CITY OF ALBUQUERQUE

December 18, 2014

**Re: Kirkpatrick Warehouse
Kirkpatrick Warehouse Drainage Report dated 11-25-14
Kirkpatrick Grading and Drainage Plan with Engineer's Stamp Dated 11-26-14
(C17D122)**

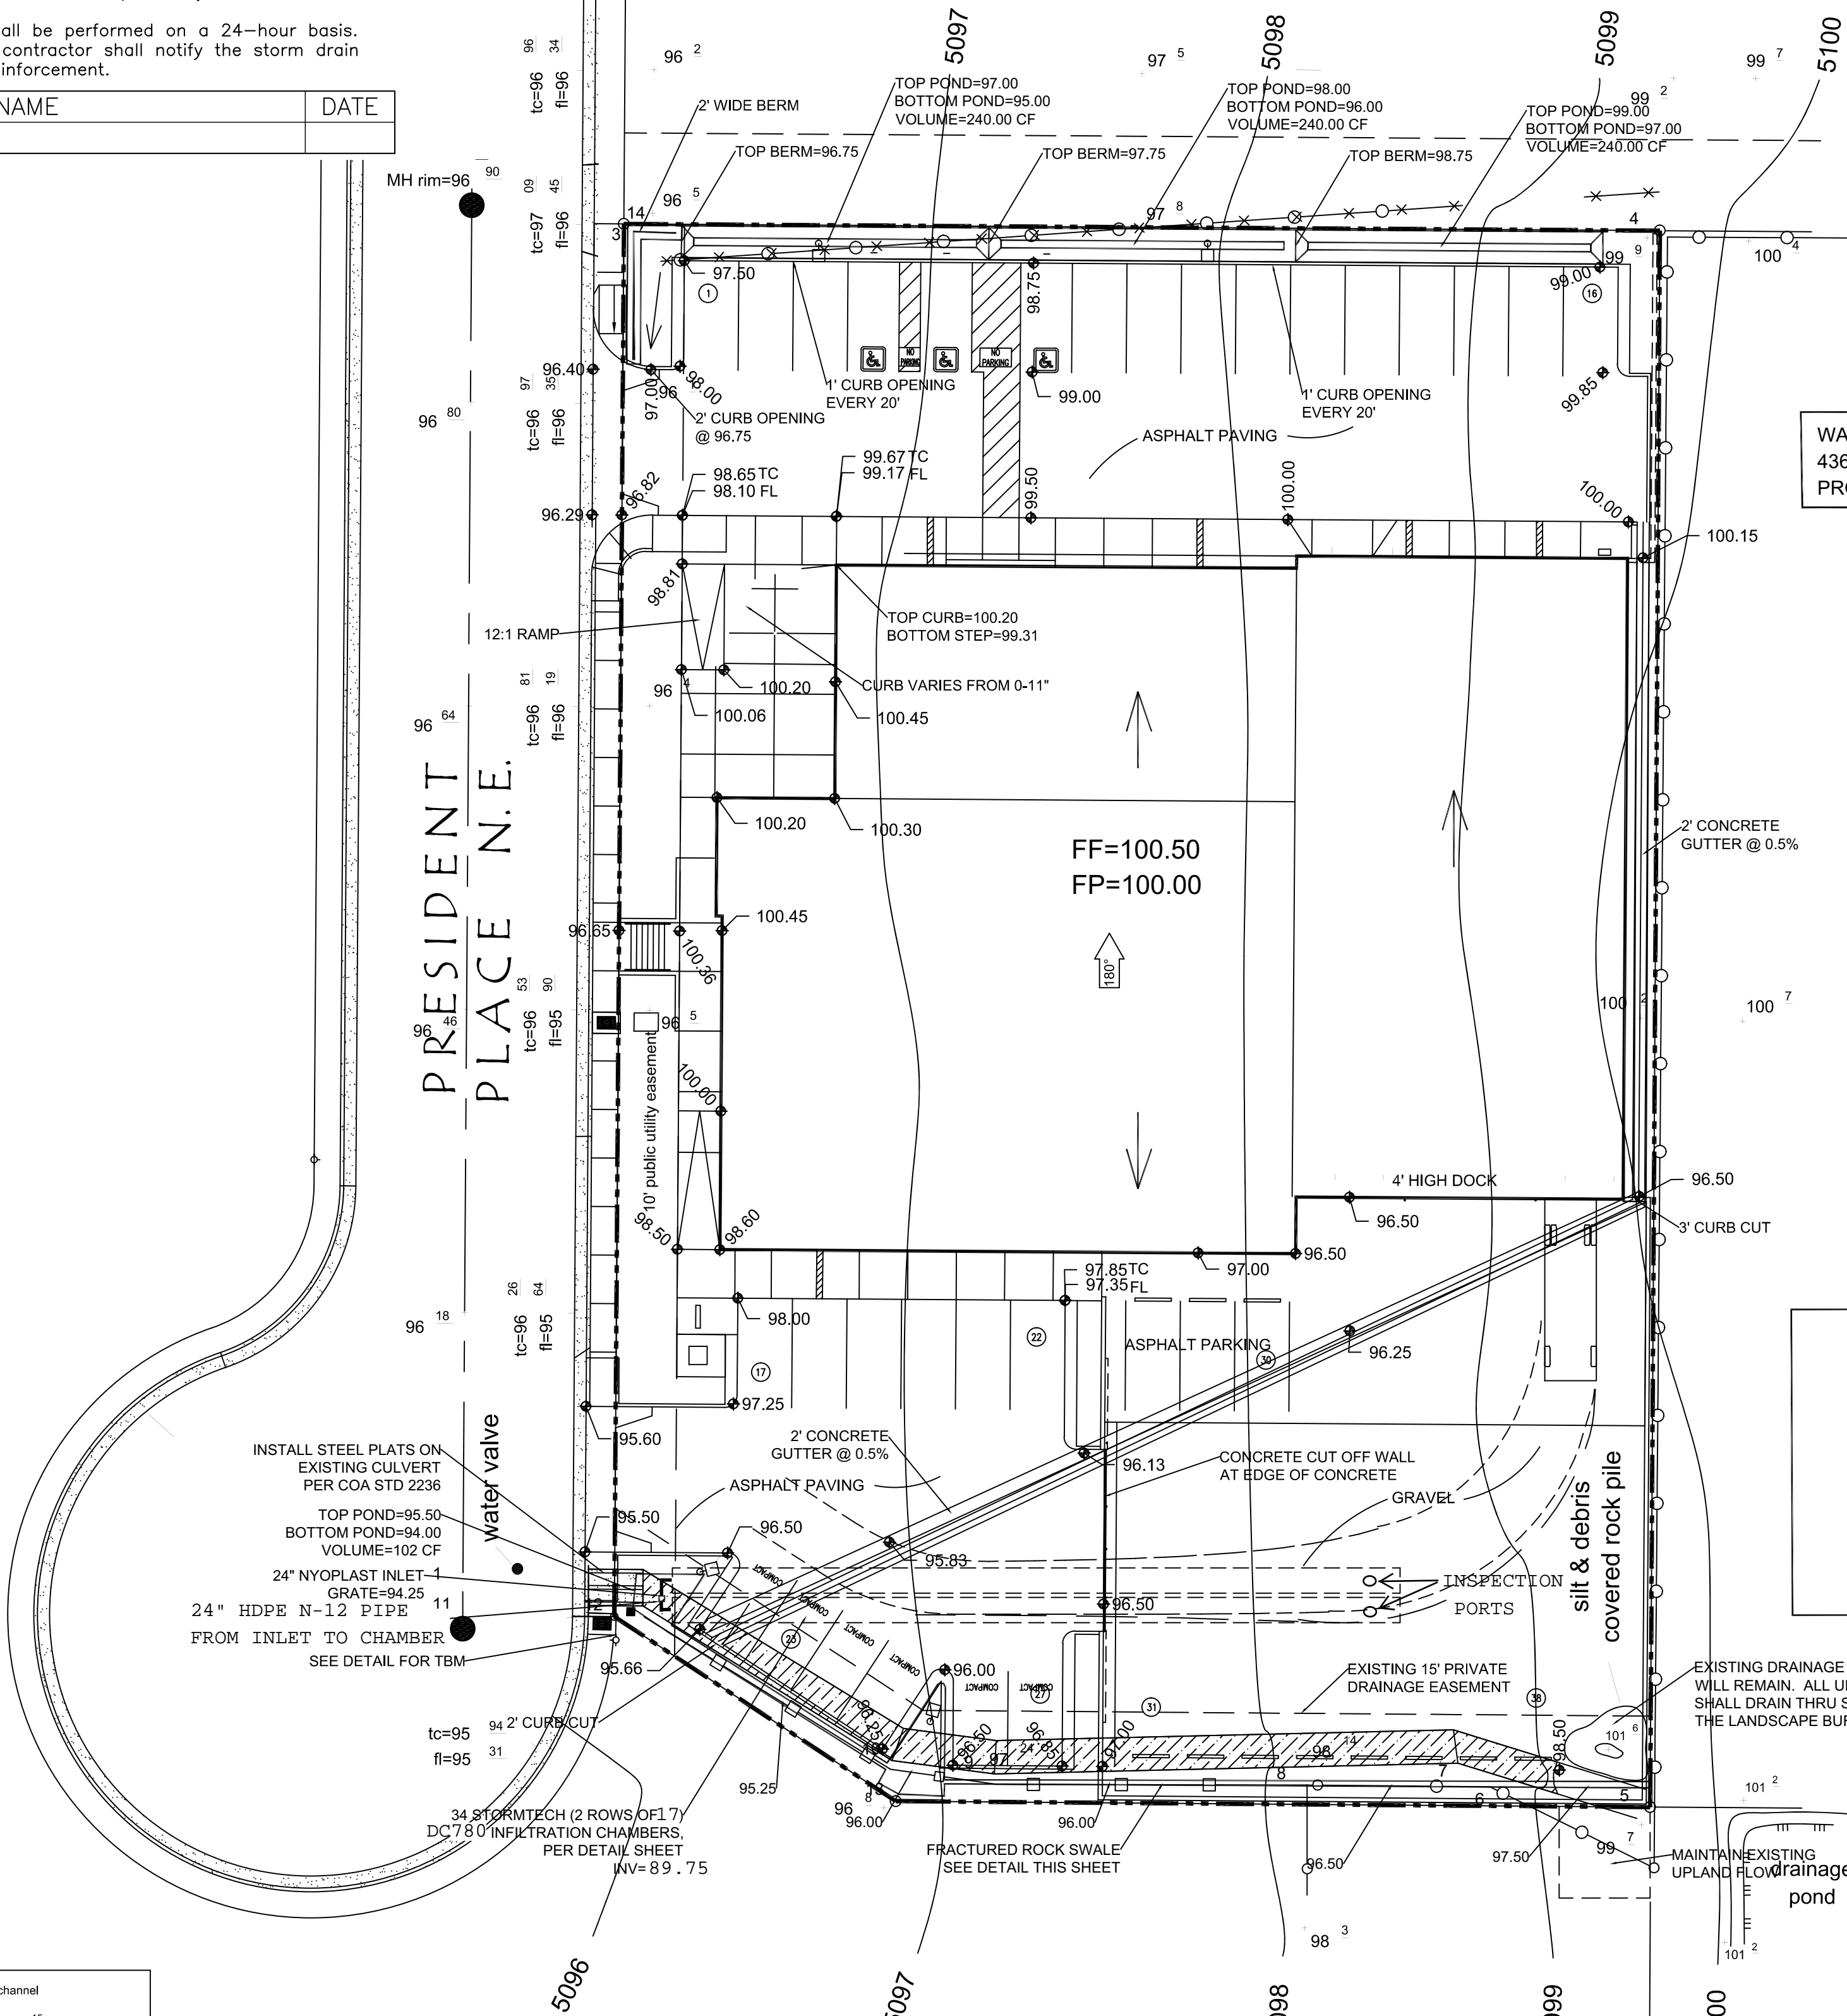
1. Provide a steel plate for the existing culvert draining to the curb per City Standard Drawing 2236 with modified detail B-B. Since this will require work in the ROW, include a SO-19 request and SO-19 language on the plan.
2. Add a valley gutter detail to the plan.
3. Call out a curb opening where the storm water drains from the valley gutter to the pond inlet.
4. For the First Flush, you only need to multiply 0.34 inches times the impervious area of the site not the entire area of the site.
